State Significant Development – Brewongle Solar Farm (SSD-64834490)

I refer to the above project and the Environmental Impact Statement (EIS) currently on public exhibition.

Council has had an opportunity to review the EIS as submitted and provides the following comments as to the matters contained within.

Figure 1 (Modified from Figure B12 in SWIA)
Flood Afflux - Probable Maximum Flood (PMF) Change in Peak Flood Depth

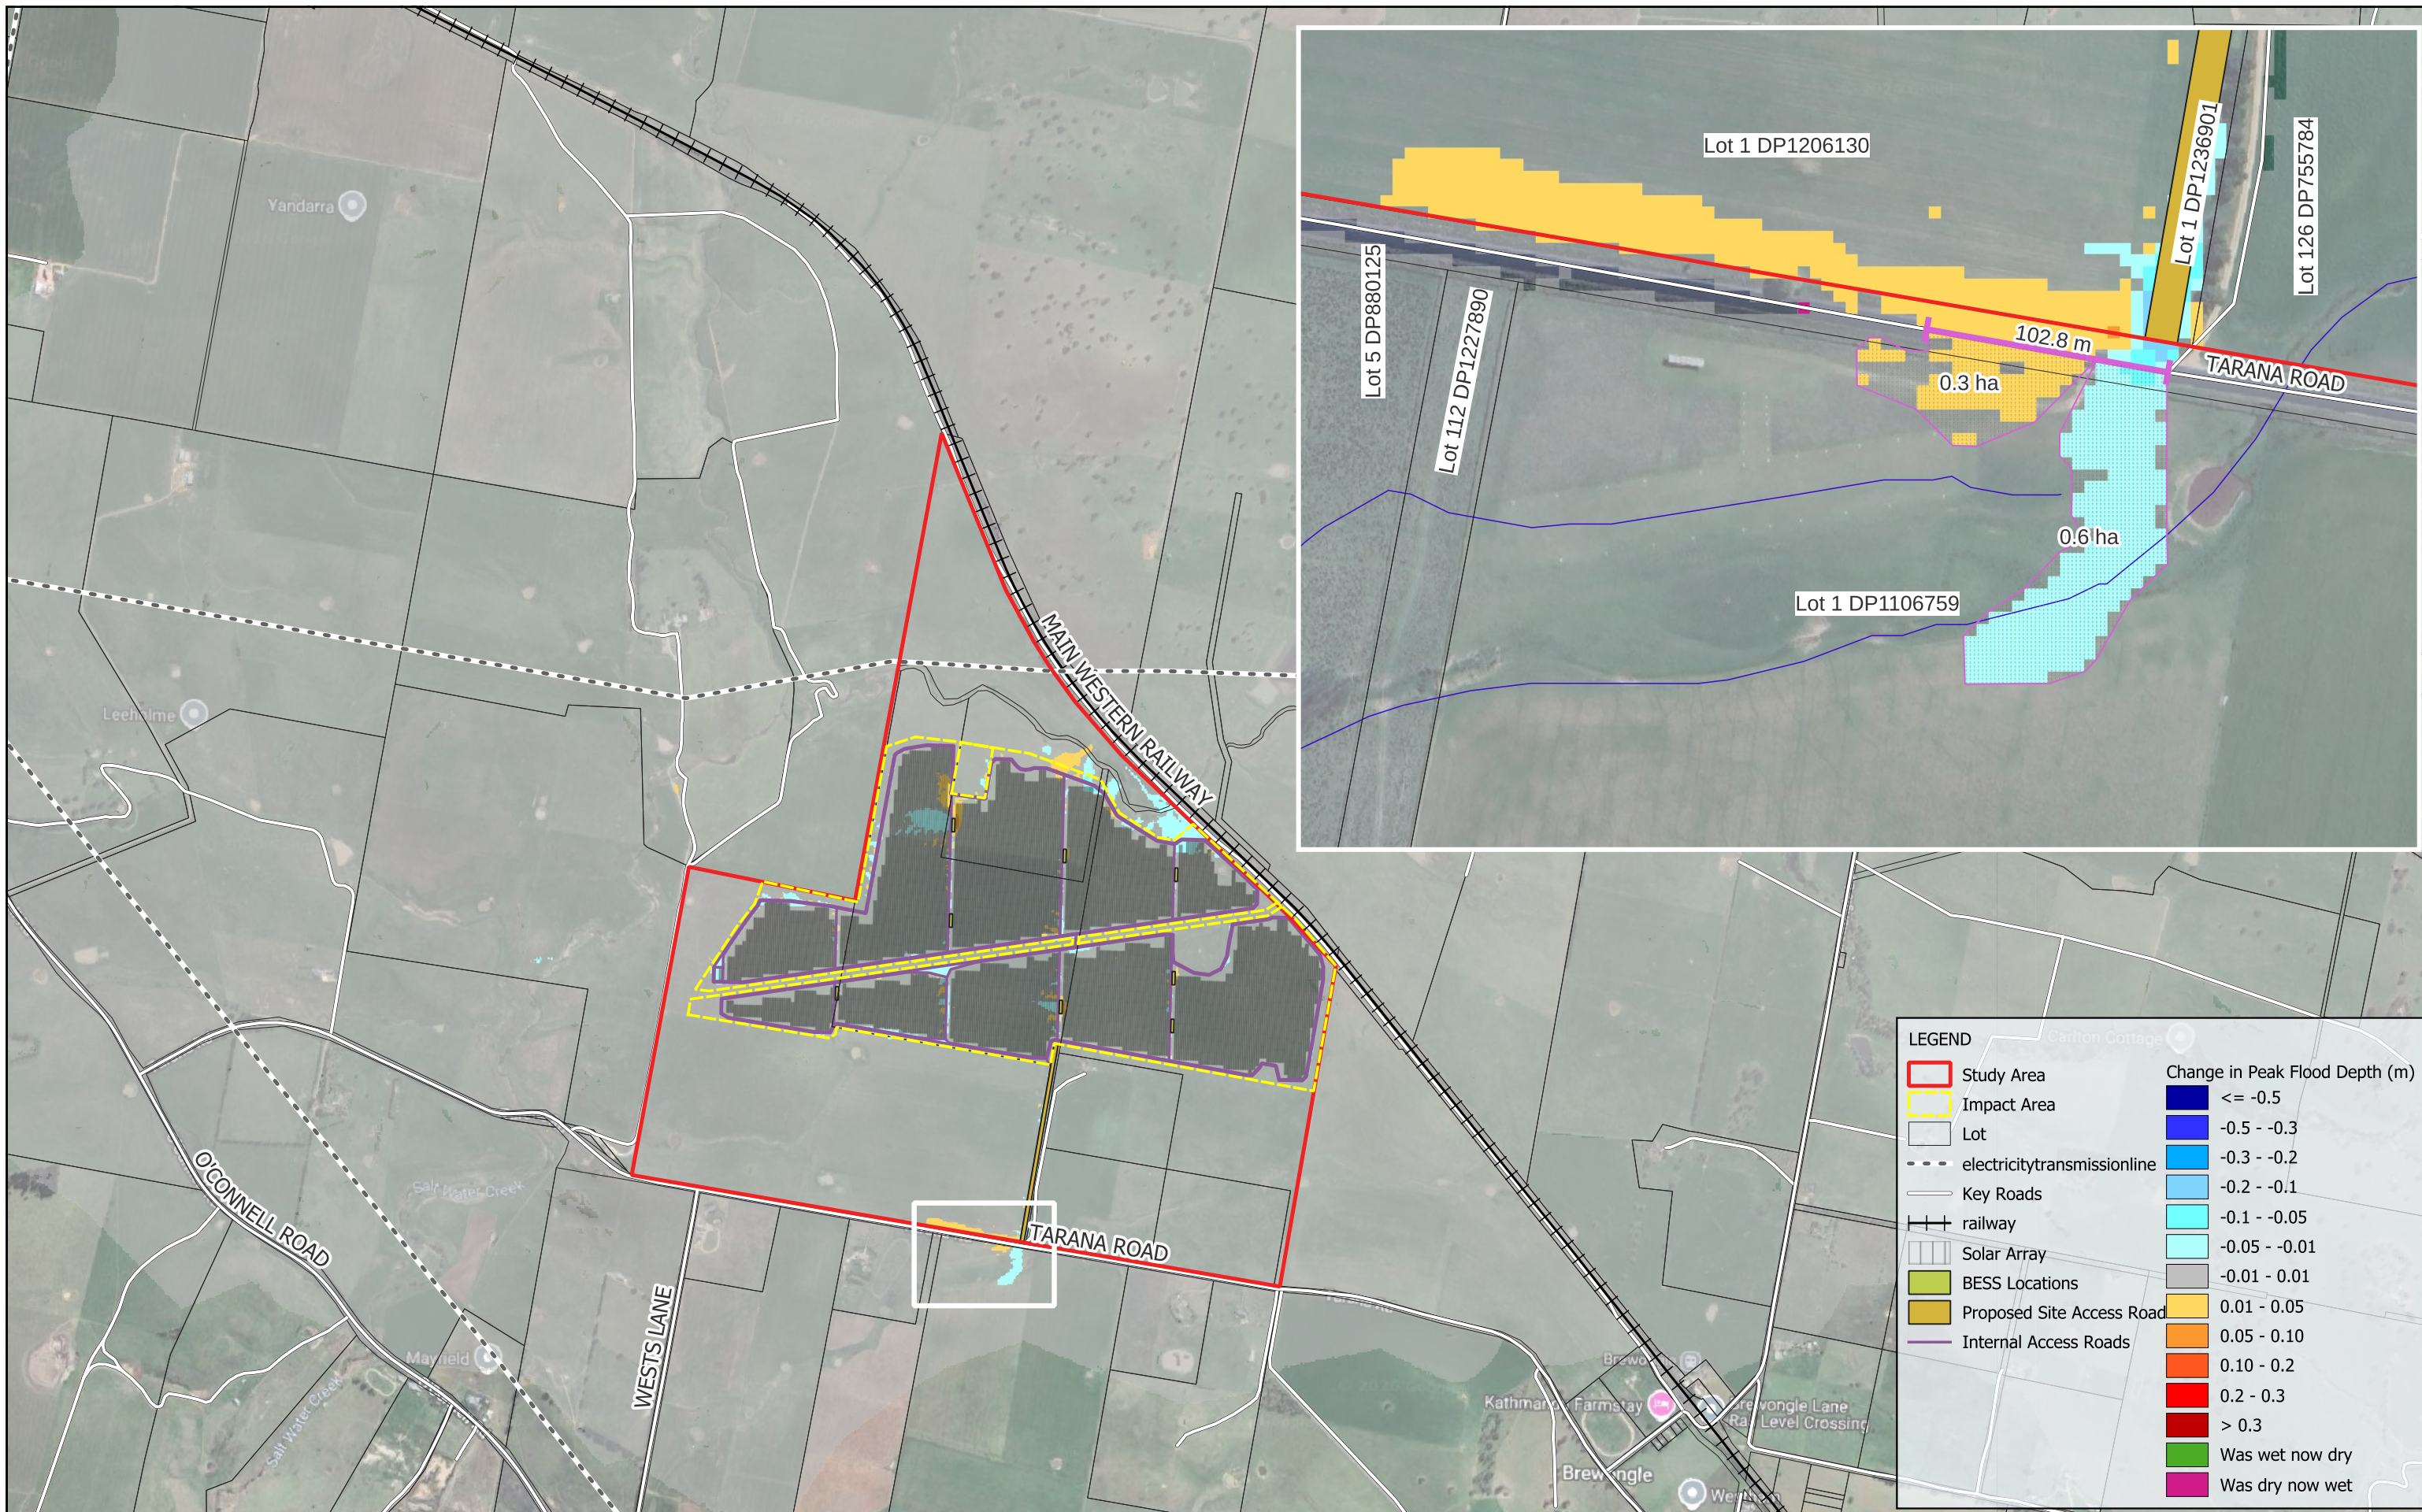
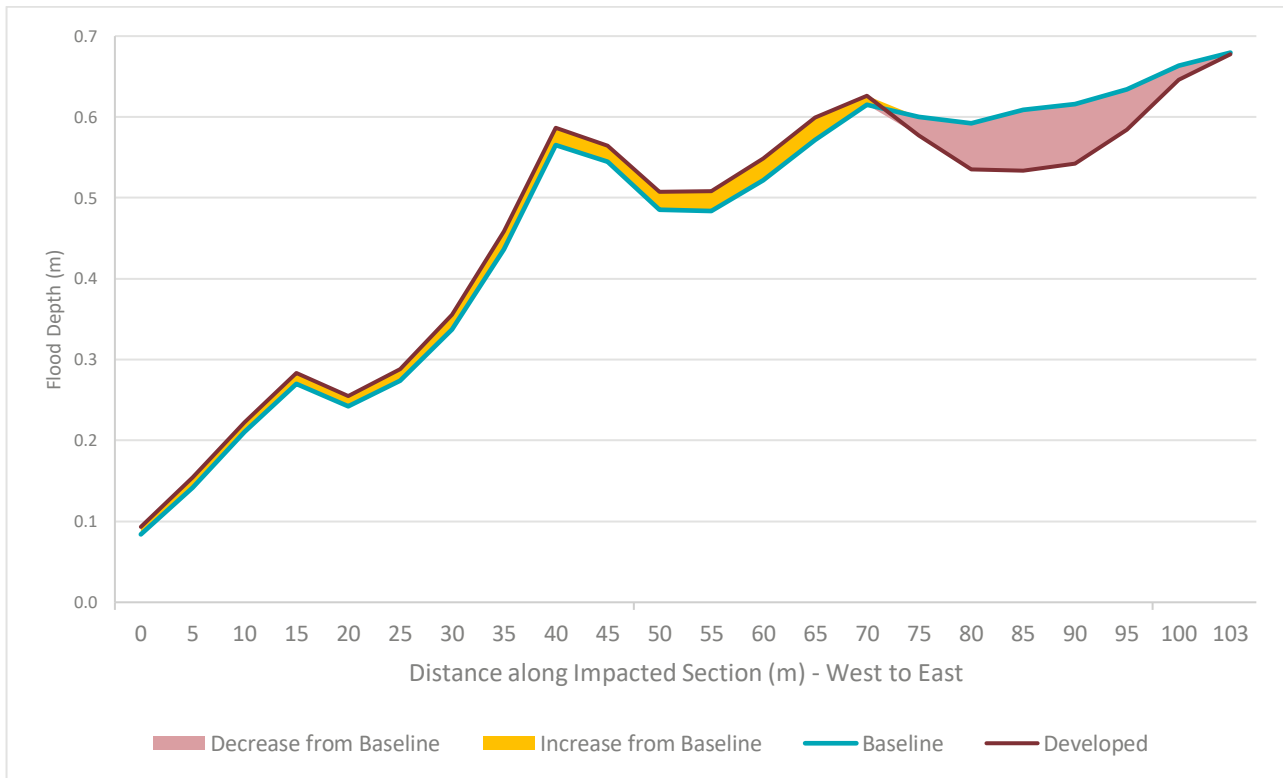
Whilst the assessment includes consideration of impacts in the immediate vicinity of the project changes to peak flood levels and velocities have not been provided at the extent of the development to assess impact on outflows. For example, no flood level or impact is recorded at the outflow of Salt Water Creek from the site, nor the two southern tributaries. Generally speaking, pre and post development flows should be unchanged to ensure excess runoff is not entering the catchment and changing the flow behaviour of Salt Water Creek.

Section 4.4 Development Flood Behaviour notes the only change to the baseline hydraulic model to represent the development was changes to Mannings 'n' value for infrastructure areas. No assessment has been made of the additional hardstand area and concentration of runoff likely to be caused by the solar panels. These represent a significant increase to impervious area across the site.
